# CITY OF ALBUQUERQUE

February 17, 2005

**Re: Journal Center Lot 1, 7400 Washington St NE, Traffic Circulation Layout  
Engineer's Stamp dated 2-16-05 (D17-D3AA3)**

SITE PLAN

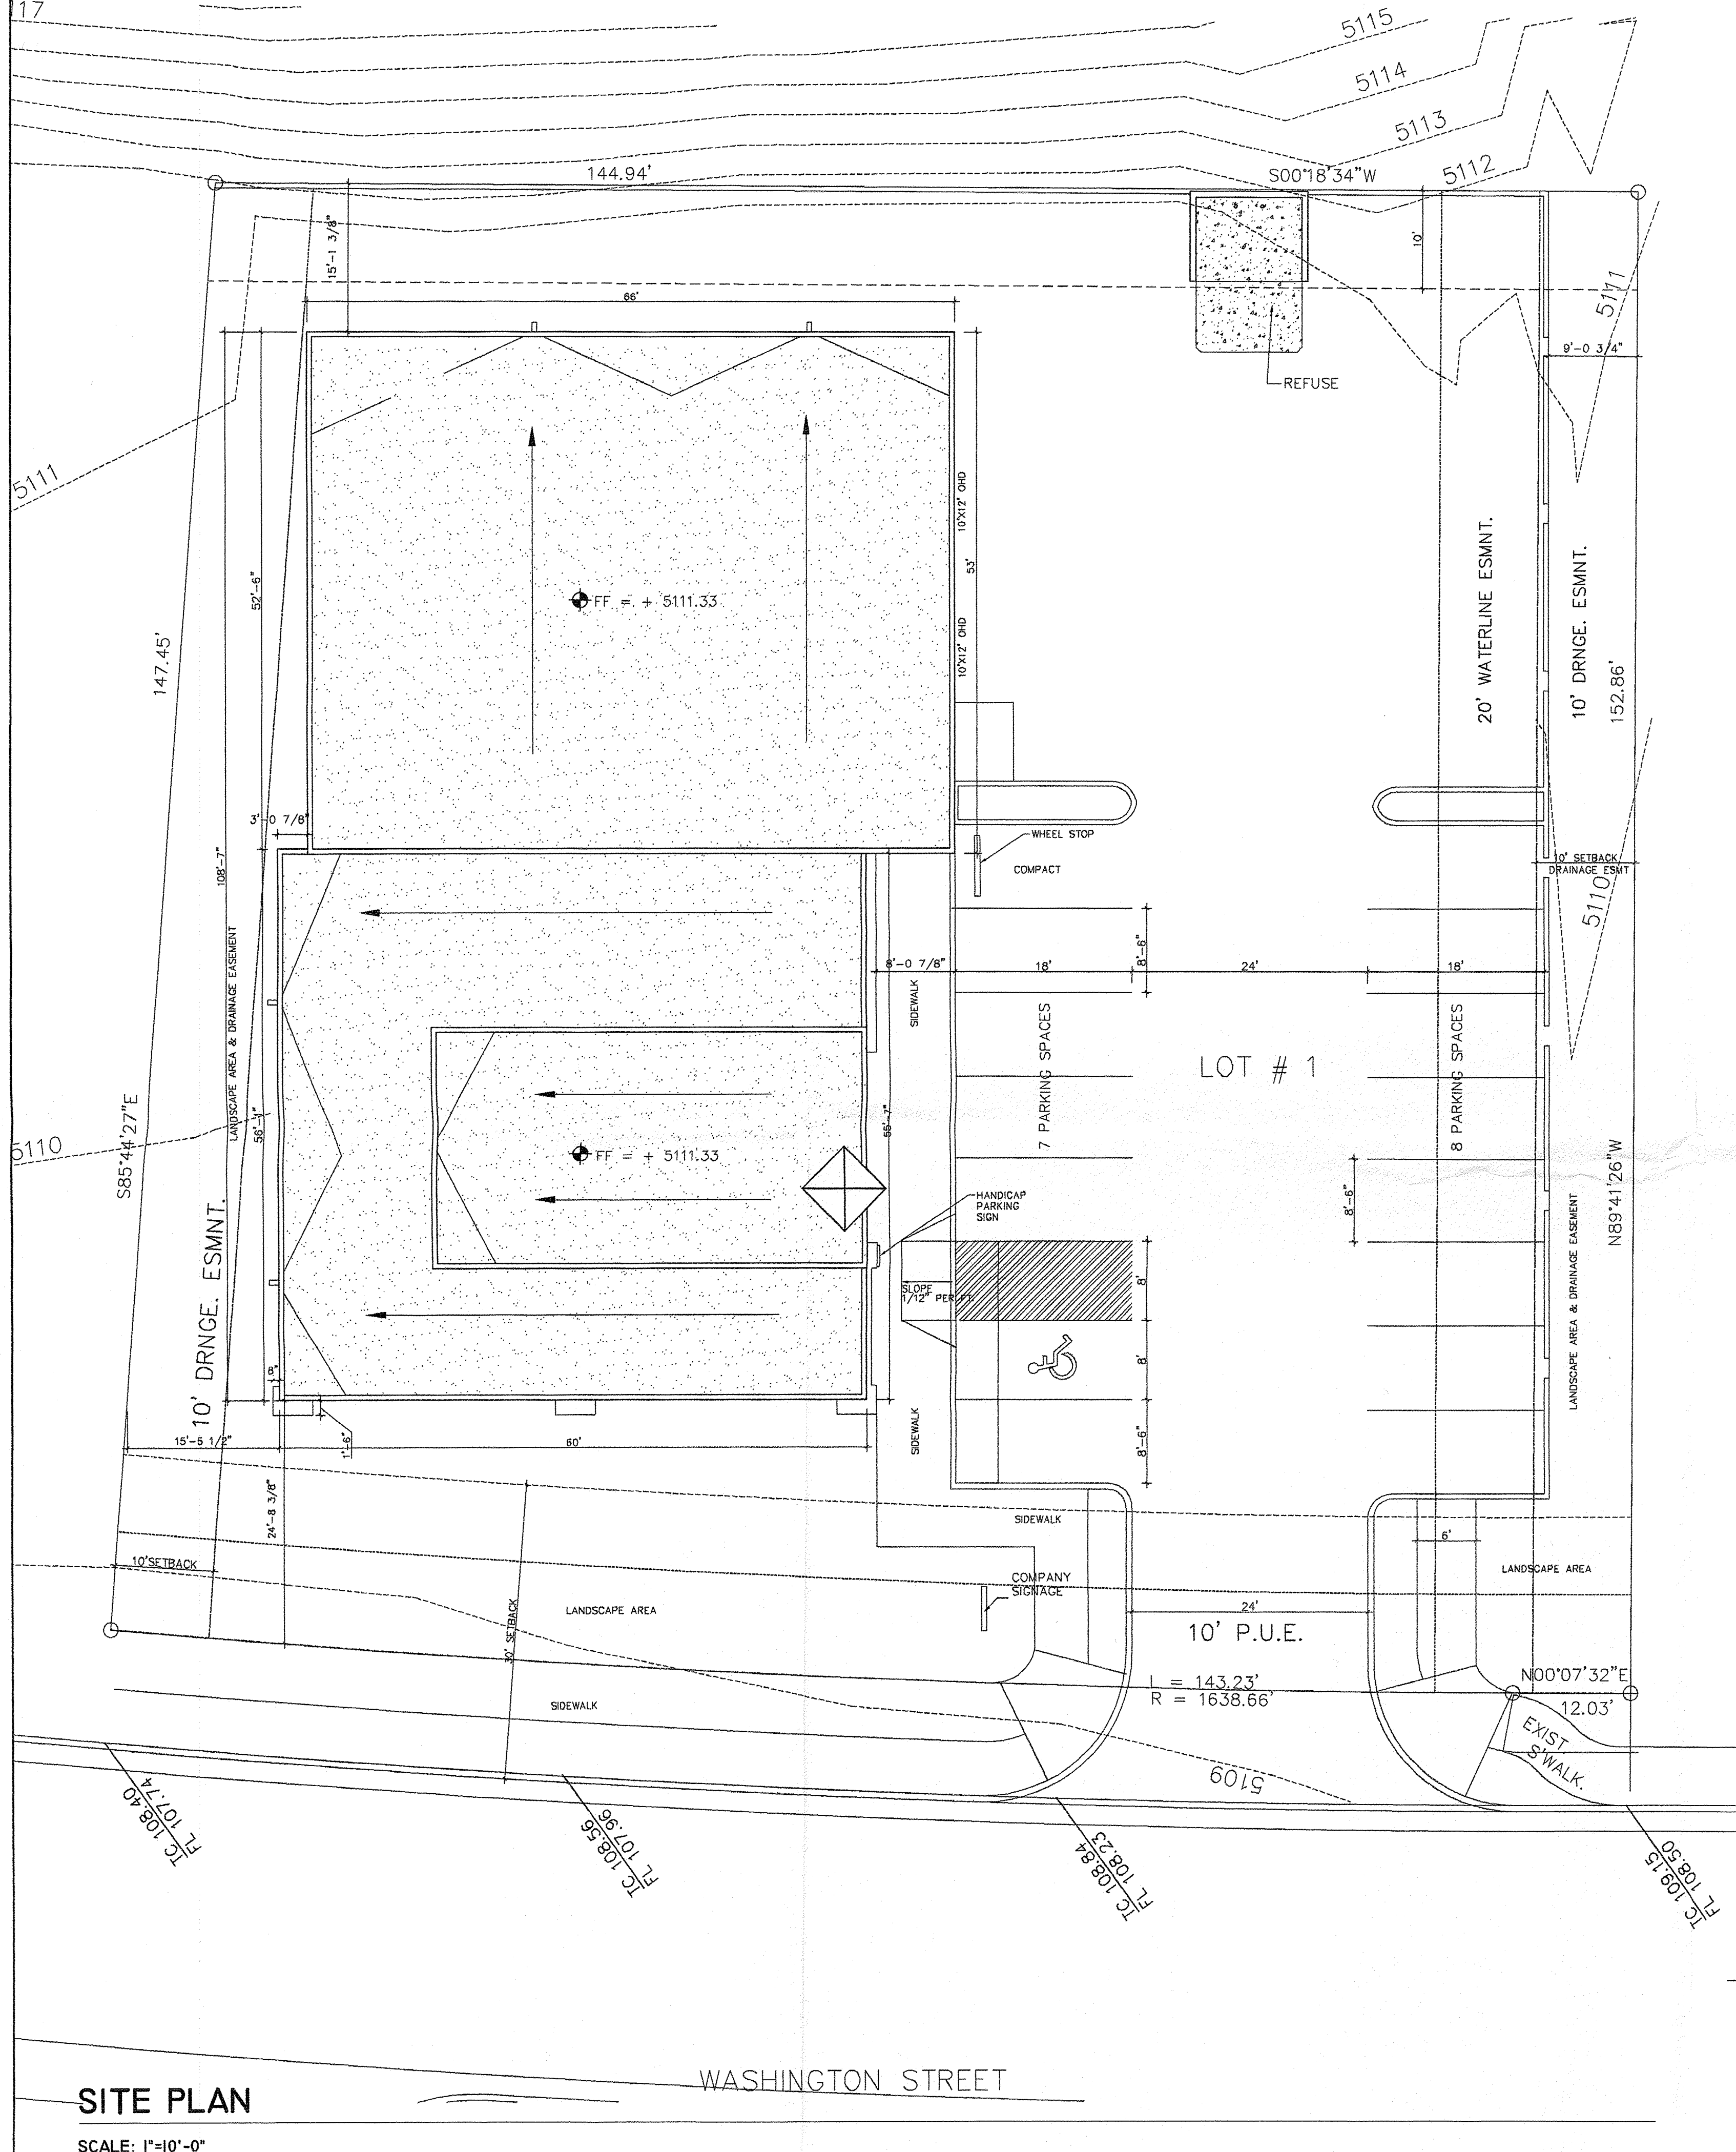
1. List radii for all curves shown.
2. Define the width of all sidewalk.
3. Is the driveway shown existing or proposed?
